From: Maria Tomalova <Maria.Tomalova@arun.gov.uk>
Sent: 21 October 2020 18:05
To: Planning.Responses <Planning.Responses@arun.gov.uk>
Subject: FW: AL/70/20/PL - Norton Lane

This is a letter regarding the proposed development of a 6 residence mews in Old Dairy Lane, Norton - AL/70/20/PL and our objection to it.

The reason for this letter is to draw attention to the seeming inaccuracies in the Environmental Design Statement and the implications this would have for the application's claimed sustainability.

Proposed Site Plan

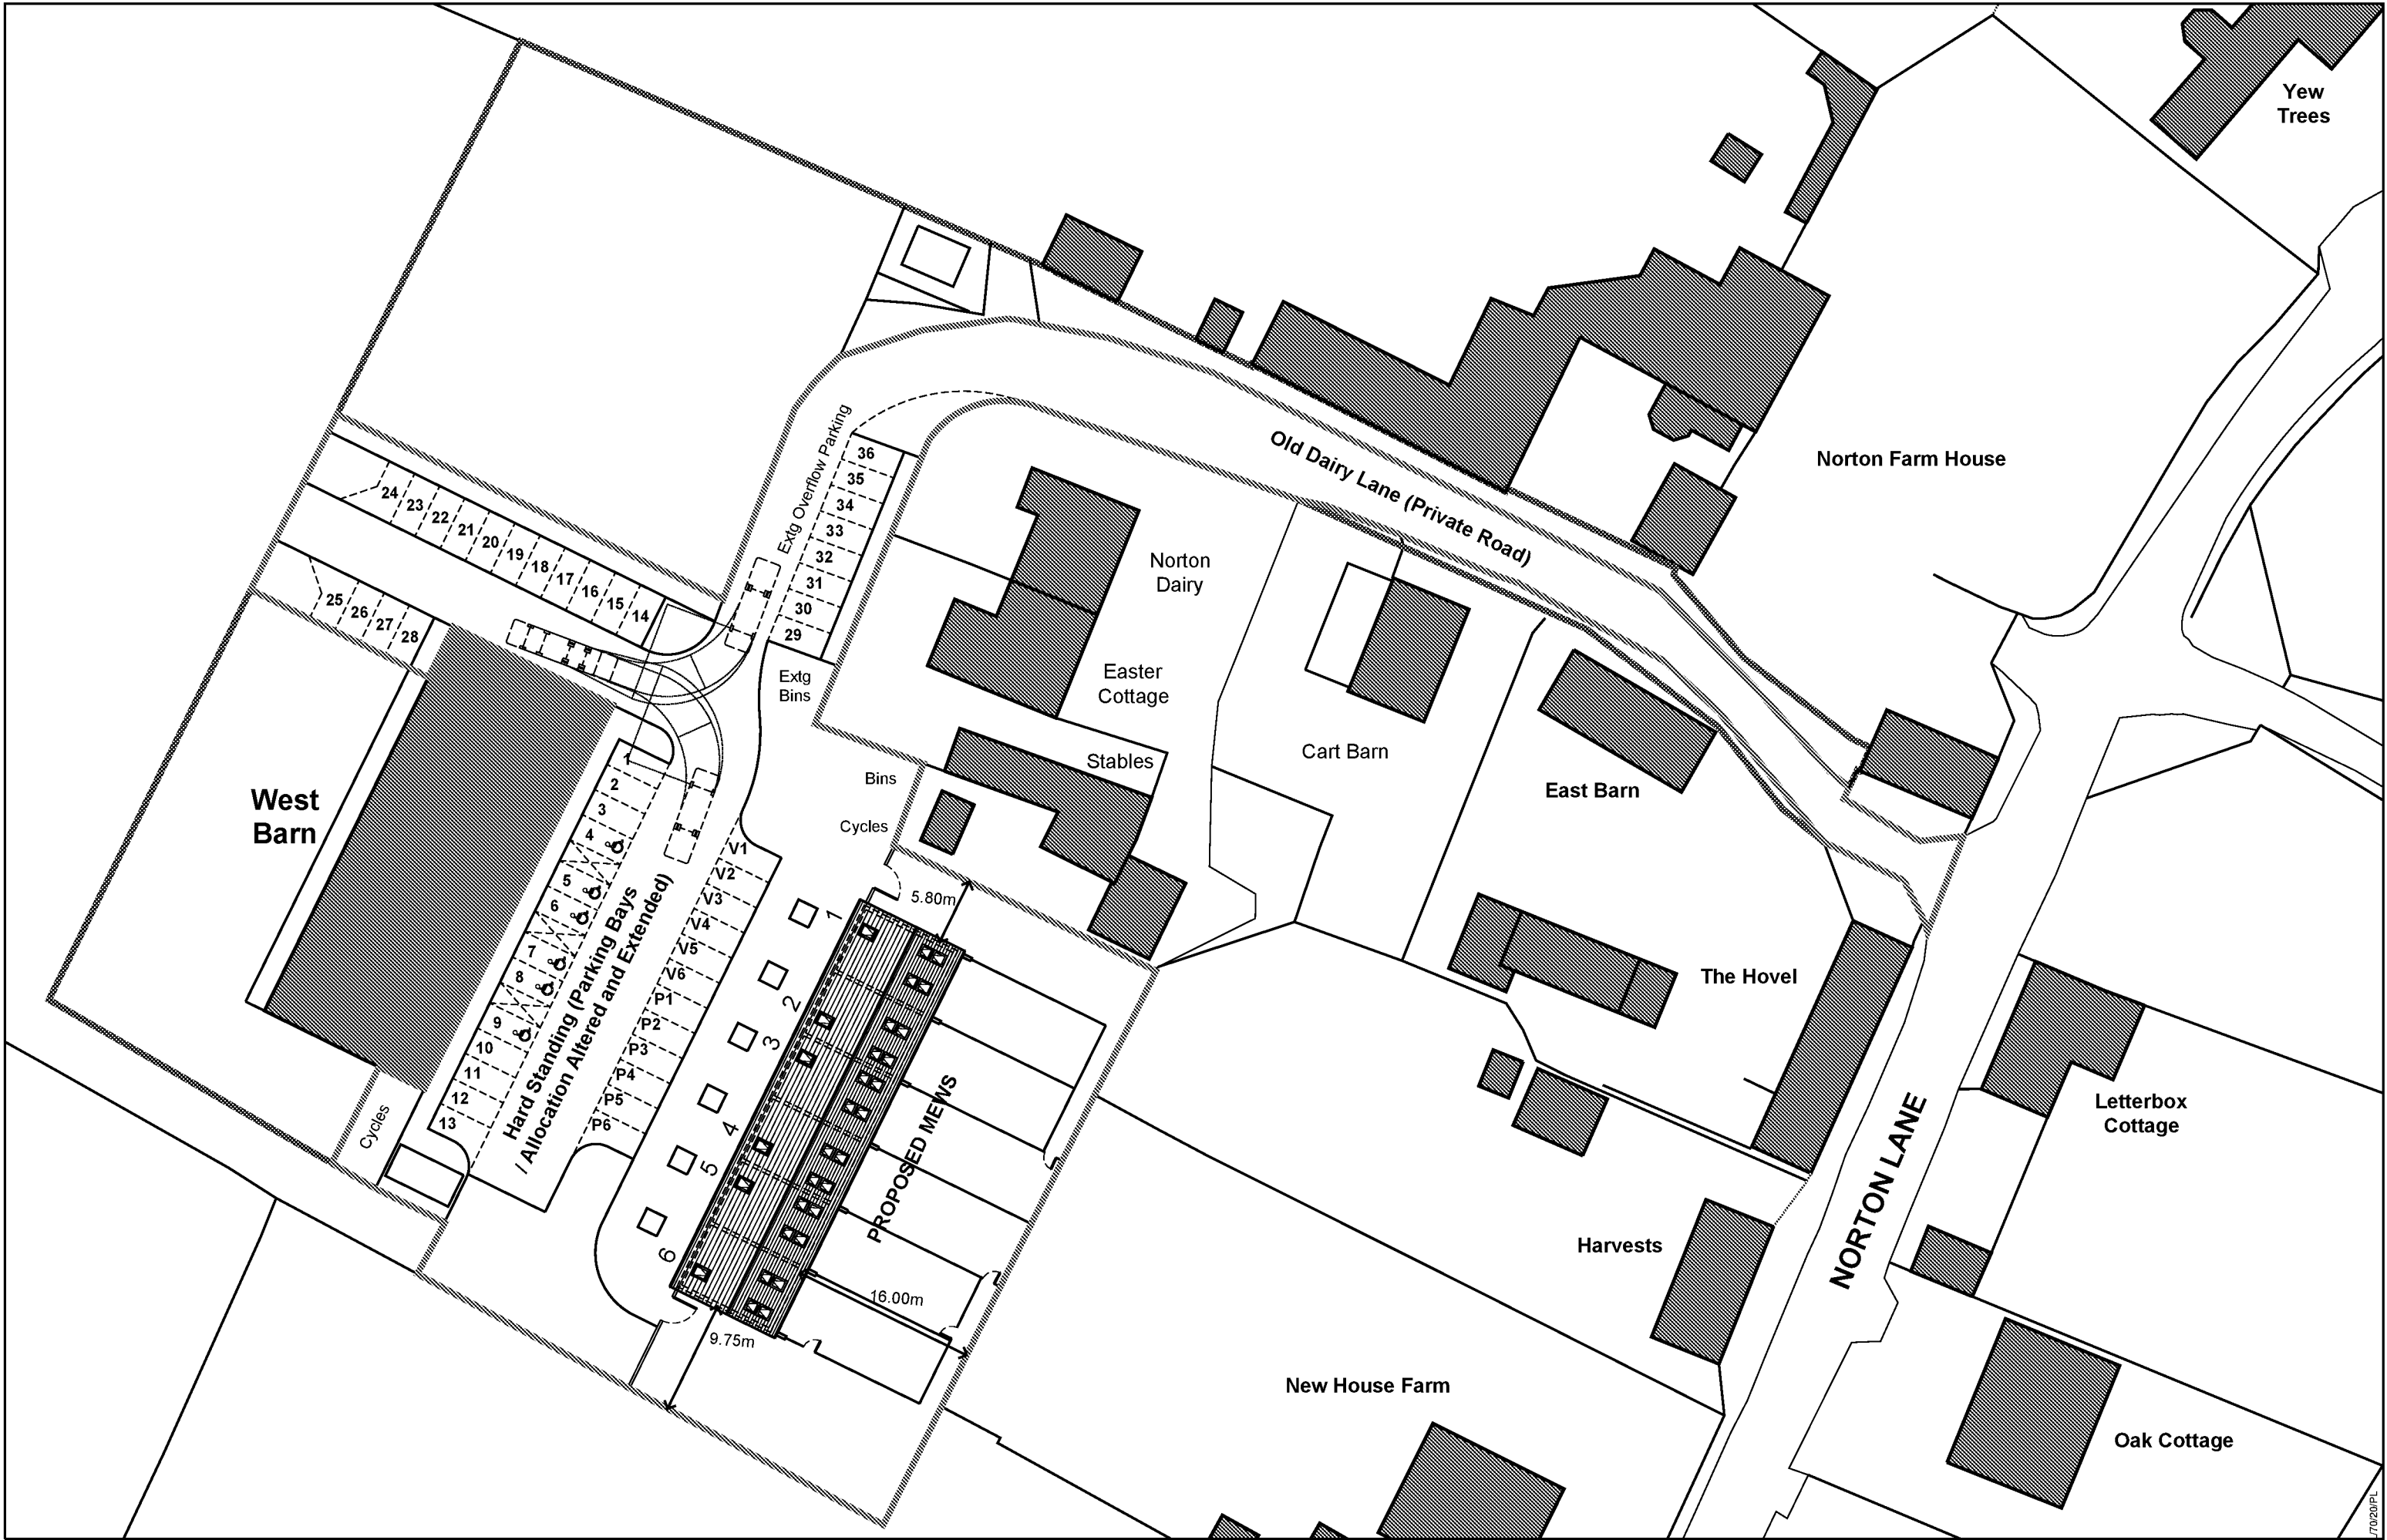
The information available on this matter can be found by checking the latest data provided by DEFRA (Department for Food and Rural Affairs) on the Carbon Grid Factor which states that the CO₂ emissions per KWh on the National grid now stands at 136gCO₂/kWh with predictions that this will fall to 41gCO₂/kWh within 15 years. LPG has a rate 58% higher than this at 215gCO₂/kWh. Add to this that heat source pumps can produce 4 times more energy than they consume by taking free and clean energy from the heat in the air/ground and this means that even at today's national grid rates an LPG system will emit at least 5-7 times more carbon than a well installed ground source heat pump with that figure set to rise to more than 15-20 times the carbon emissions by 2035 as the National Grid moves rapidly towards decarbonisation. The Council for Climate Change are suggesting all gas boilers should be banned from new builds because they are viewed as unsustainable. Even with good insulation the proposed set of six households run on LPG combined with all of the extra car travel associated with living in a rural village without local shops or regular public transport would create a very much higher level of carbon emissions than could be reasonably considered sustainable. The LPG will also need to be regularly tanker delivered from a distant depot through Norton and down Old Dairy Lane and stored and it is not clear from the block plan where gas would be stored.

2. There is a section which states that the houses may benefit from PV panels but these are not shown in the designs and none of the roofs are south facing. The local electricity supplier (DNO) may also limit the amount of solar power added to the grid as Norton is right on the limits of what extra solar it can take. A recent 36 panel 10KW installation in a neighbouring property (AL/104/18/HH) was limited to just 7KW output because of the higher peak voltages in the Norton area. To make any meaningful contribution to the reduction of carbon emissions for 6 properties a pretty large PV installation would be required.
